Our Case Number: ABP-316272-23

Re: Bus Connects Templeogue/Rathfarnham to City Centre Core Bus Corridor Scheme
Templeogue/Rathfarnham to City Centre

**Templeogue/ Rathfarnham to City
Centre Core Bus Corridor
Scheme Submission (Ref. No.
316272)**

Submitted on Behalf of:
Anna Shanley and Ryan Stempniewicz,
14 Terenure Road East, Dublin 6 (D06ET35)

TYPICAL SECTION G-G
TERENURE ROAD EAST
LOCATED ON GA SHEET 07
DRAWING REF: BCIDC-ARP-GEO_GA-1012_XX_00-DR-CR-0007

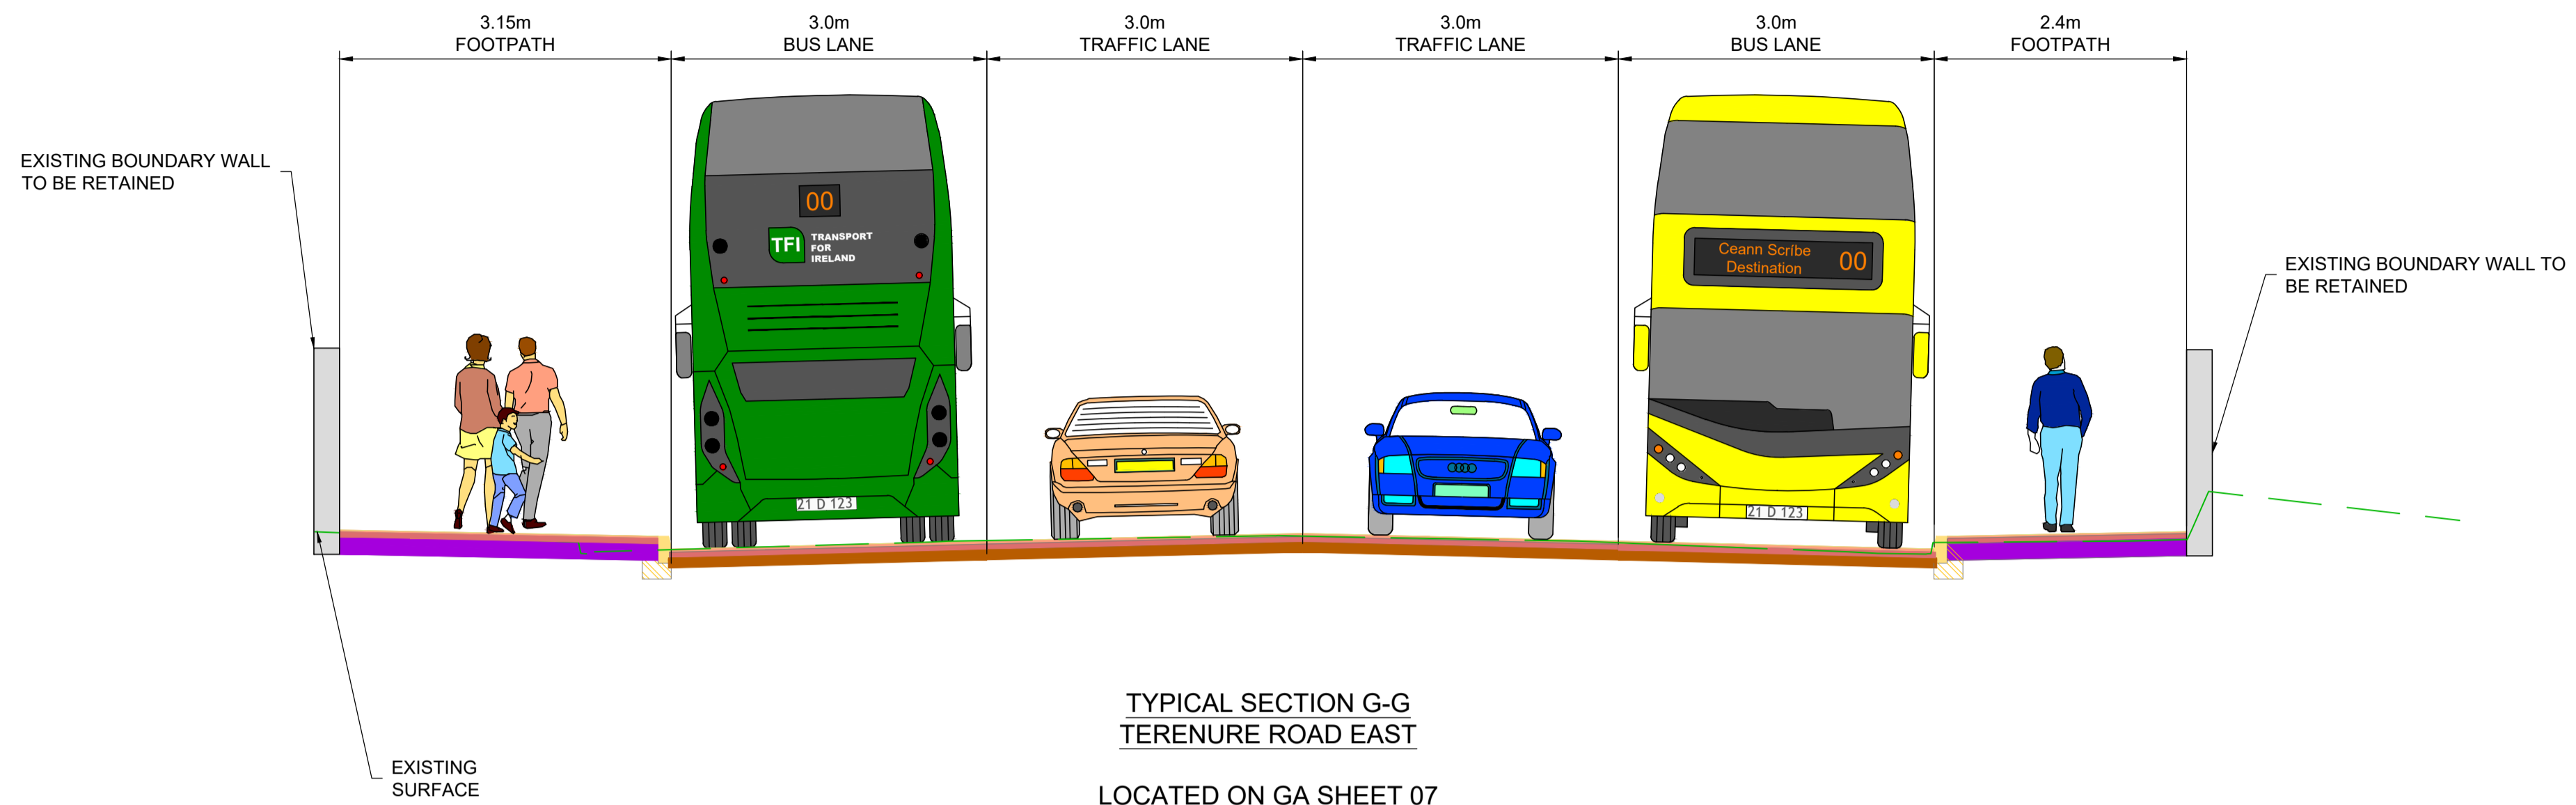
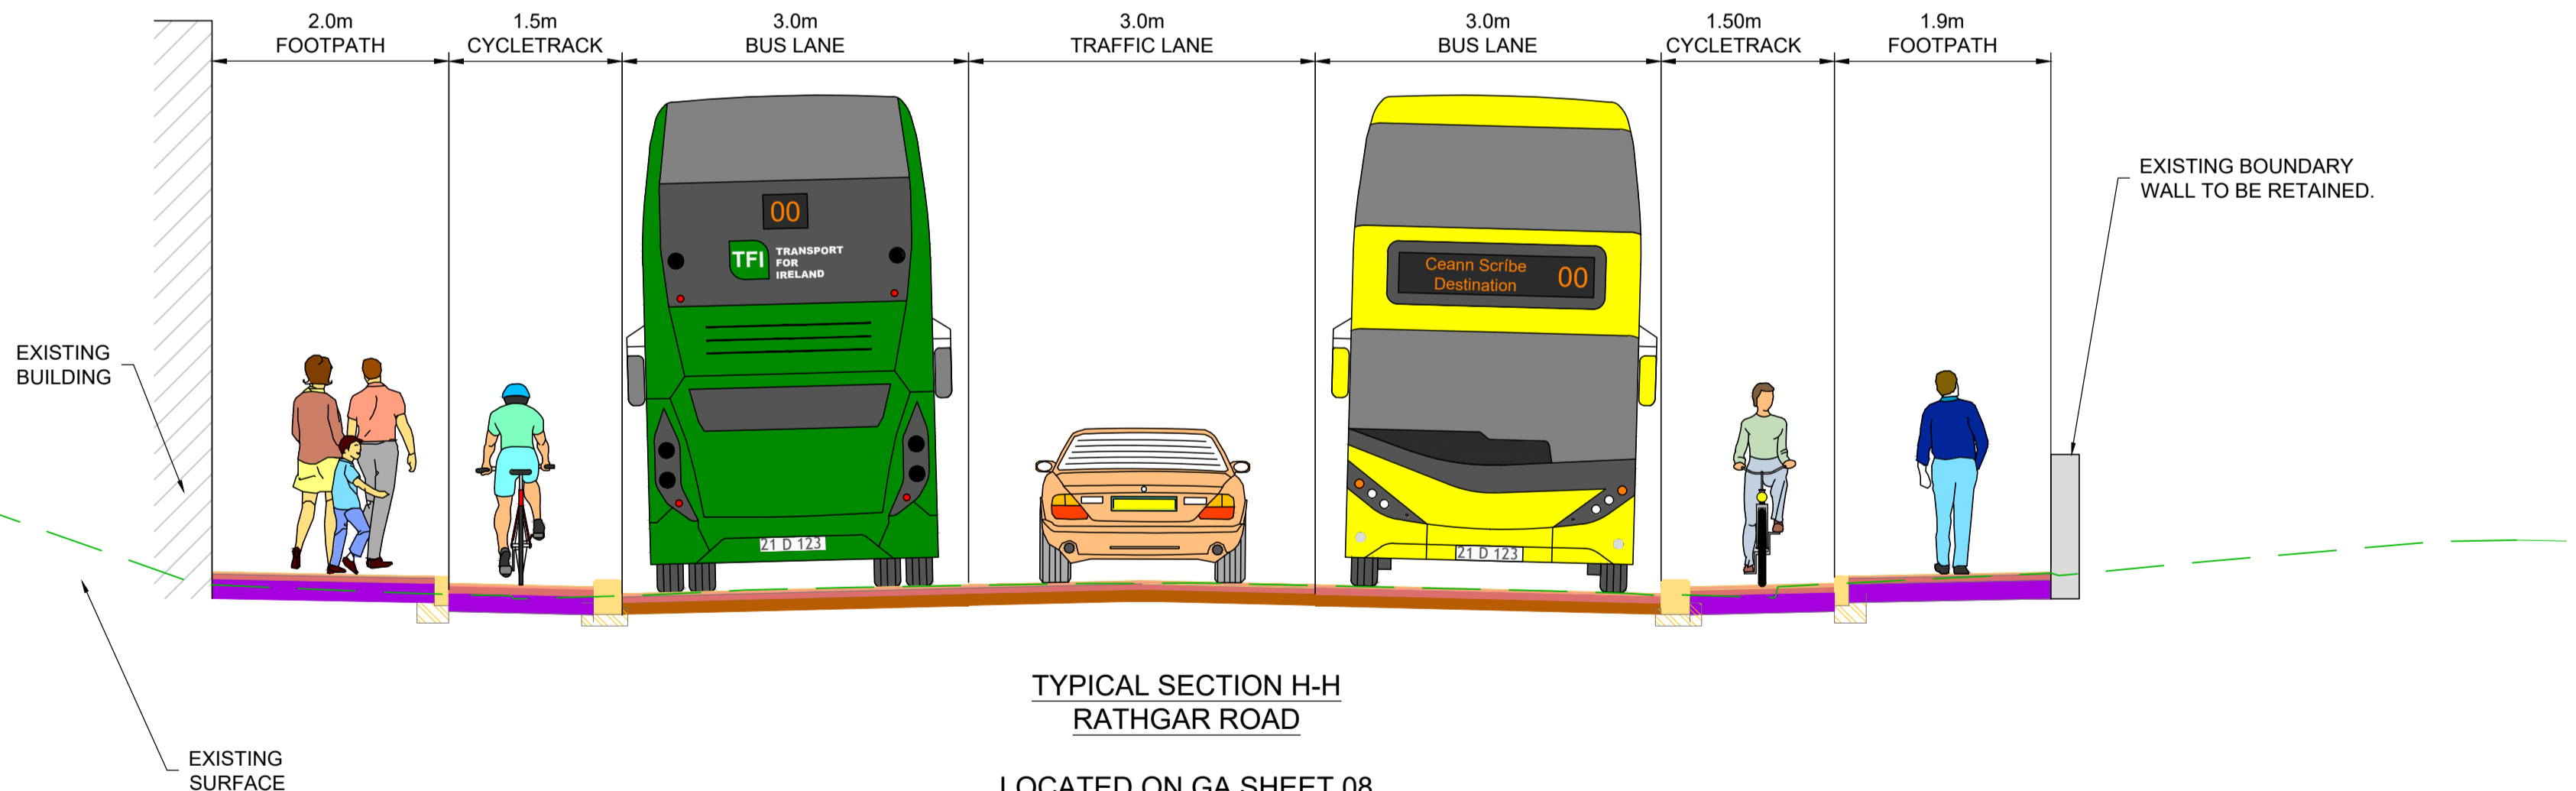
The bus stop, as identified in Figures 9-10.0 overleaf, will be in permanent operation and will result in excess traffic building up outside the property as well as in the village centre which contains a major junction at Terenure Road East and Orwell Road. This will affect our client's ability to freely access their property via car, thus reducing their amenity in contravention of zoning objectives for the site. Given the residential nature of the property, the increase in diesel buses stopping outside the property will greatly affect the amenity of the residents by resulting in excessive air and noise pollution, as well as creating a traffic hazard for anyone entering or exiting the site.

Further, the new bus stop shelter will be bookended by the access gates of two local businesses to the east, The O'Brien Press and Studio 6 School of Music (a children's music school), in a location directly adjacent to where the footpath narrows. This, combined with the nature of the intersection in which the right-hand lane is used for access to Highfield Road (and not to continue north into Rathmines), creates

both a pedestrian and vehicle pinch point. In addition, the footpath in front of No. 12 Terenure Road East is used by all of the local businesses as a loading bay for deliveries. As discussed further within, placing a bus stop in this location raises a risk of serious injury given the size and frequency of the delivery vehicles using the location. It is considered that the relocated bus stop and resulting hazard will deter people, particularly vulnerable people such as children and elderly people, from walking into the village, thus regressing the city's push for an increase in active travel.
